Development Control
Ribbles Valley Borough Council

Your ref: 2020/0465
Our ref:
Date: 28th July 2020

Re: Planning Application 20/0465

Address: Land adjacent to The Beeches 65 Whalley Road Langho BB6 8EF

Illustrative Layout and Streetscape

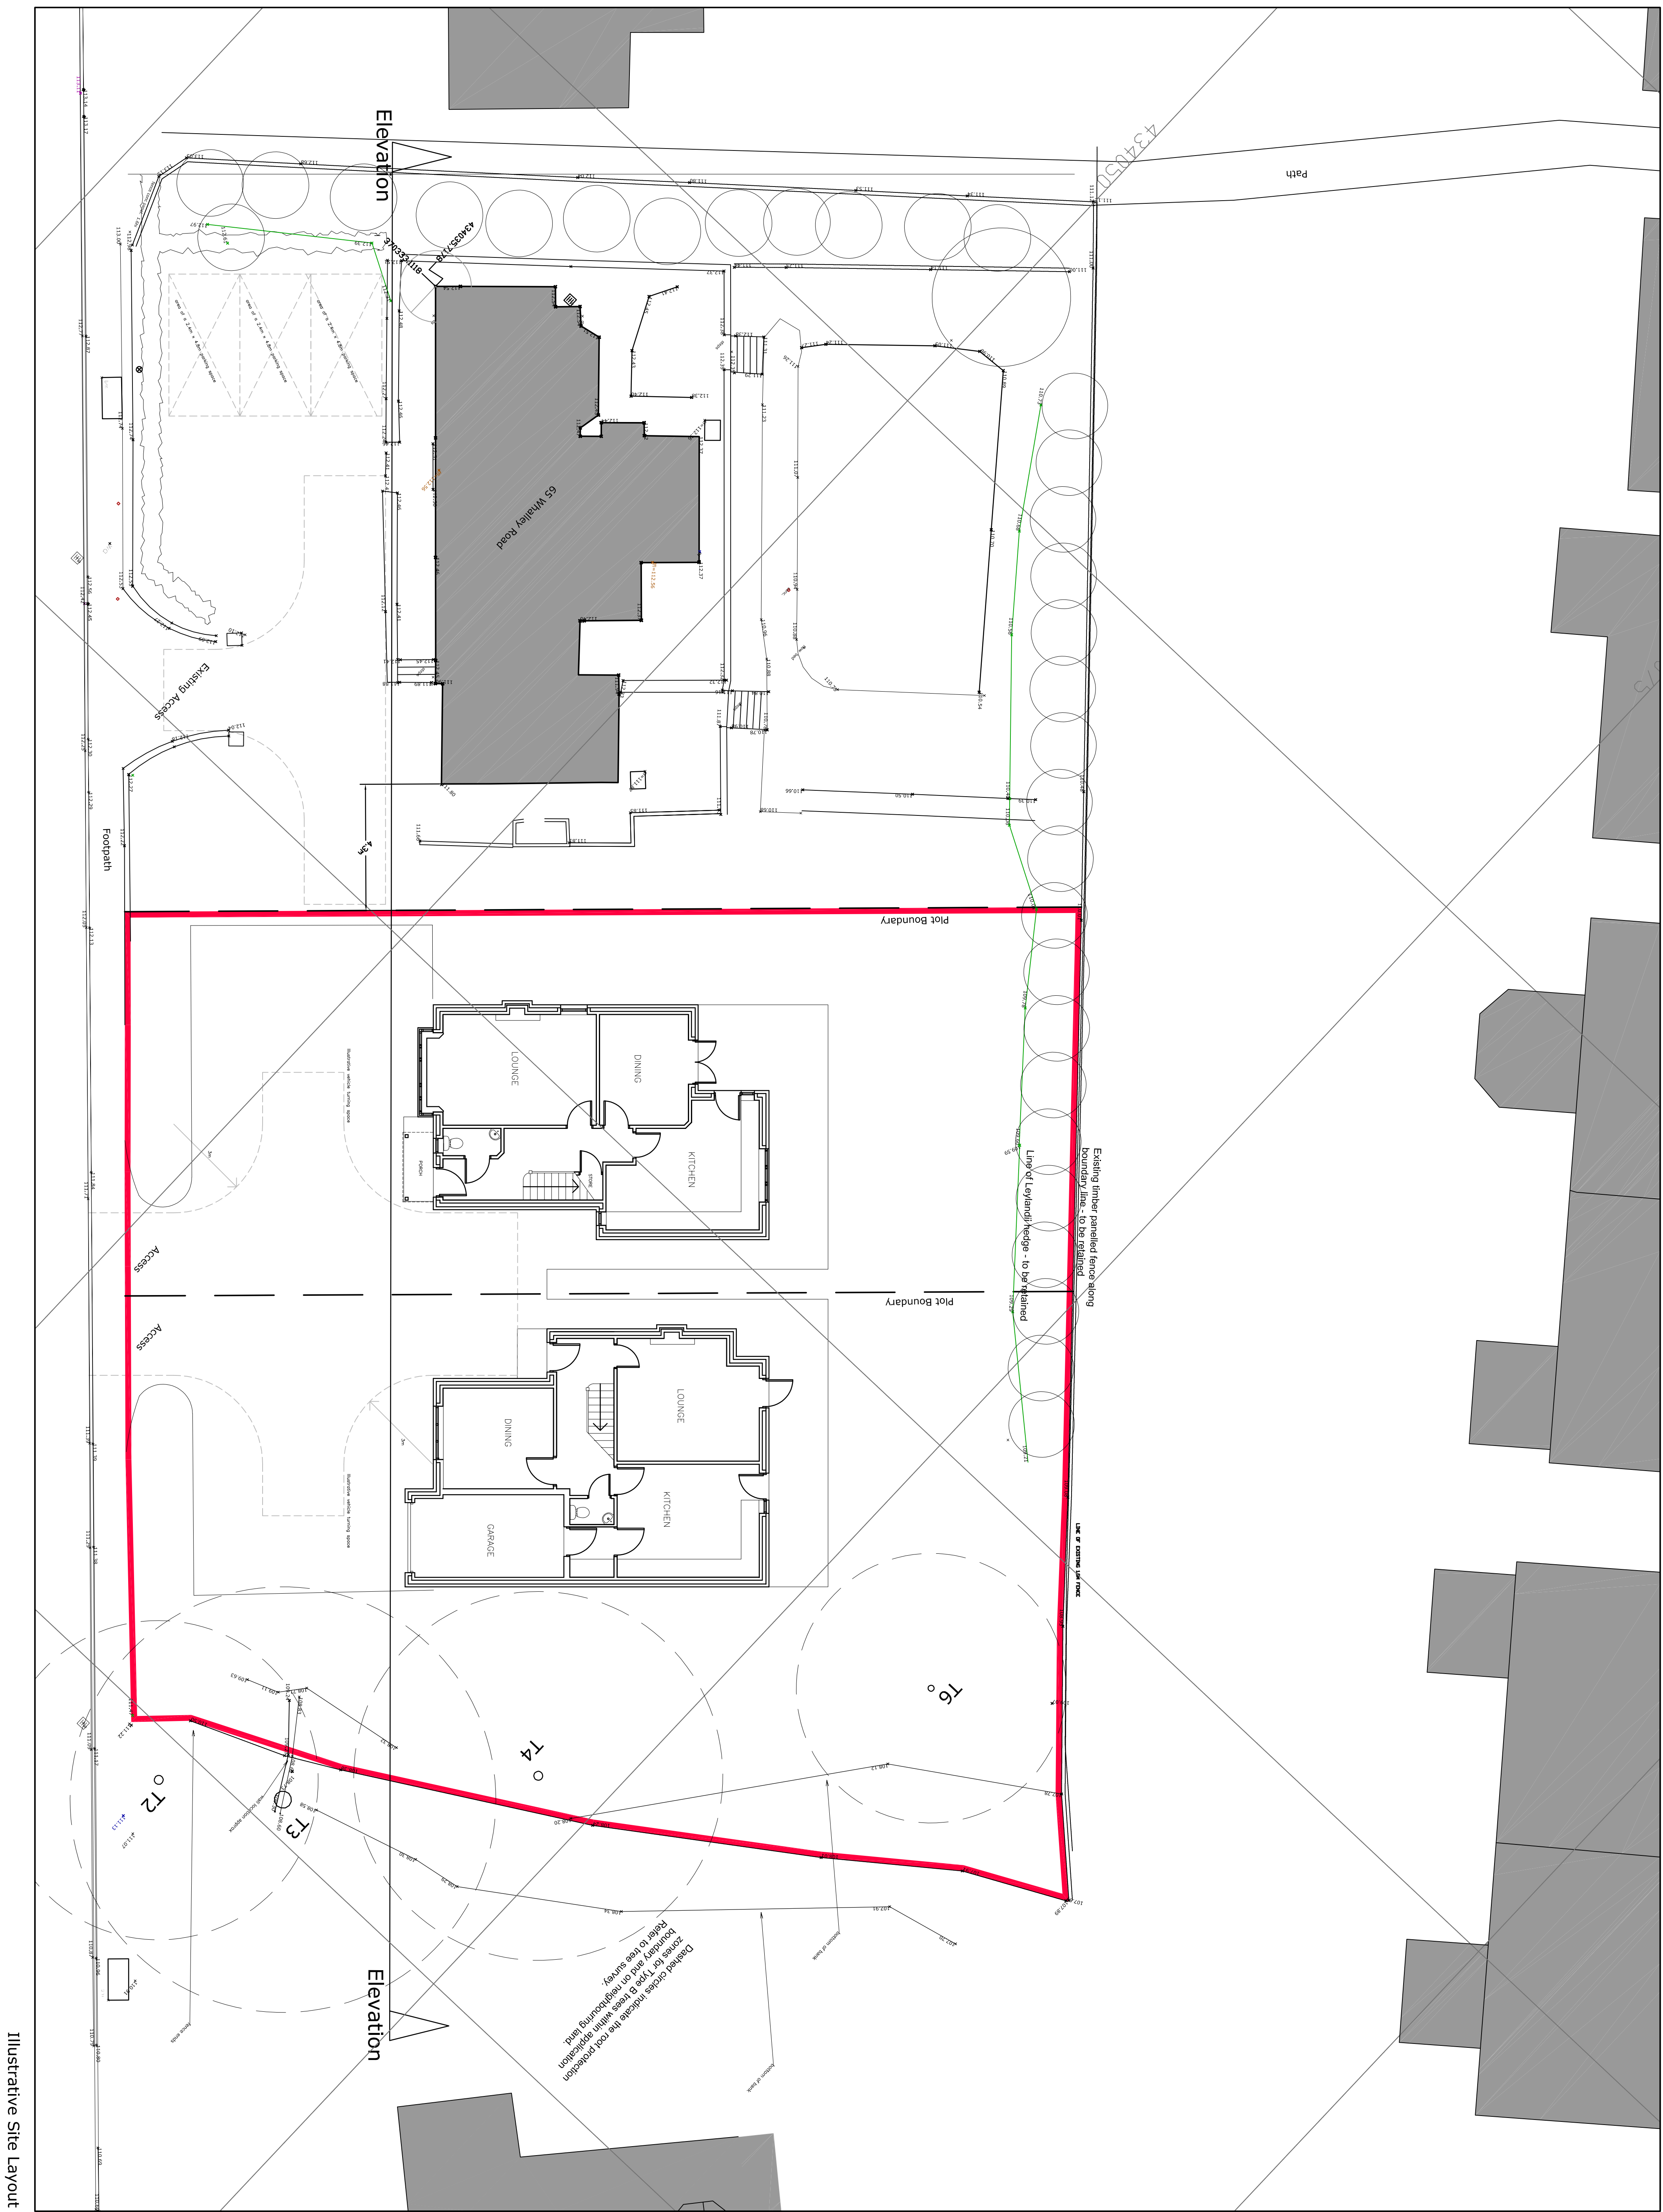
It is noted that this is a resubmission of a number of earlier applications dating from 2011. The guidance regarding the access to the properties from the highway is taken from Manual for Streets and Manual for Streets 2 which are now under review, the schematic drawing used to support the access may need to be addressed at some point in the future.

- A plan showing the Visibility Splay at 2.4m x 45m should be provided, two local traffic counts show the 85 percentile speed to be an average of 31 mph

- To accommodate any parked cars in the vicinity of the adjacent school the splay should be measured to the nearside kerb in both directions
- The width of the access should not be less than 5m the existing lower kerb may require realigning to accommodate the new access
- Each dwelling should have sufficient hard standing to accommodate 3 off street parking spaces they should measure 2.4m x 5m. The vehicles should be able to enter and exit the premises in a forward gear. A garage measuring a minimum of 3m x 6m internally is considered to be a car parking space.
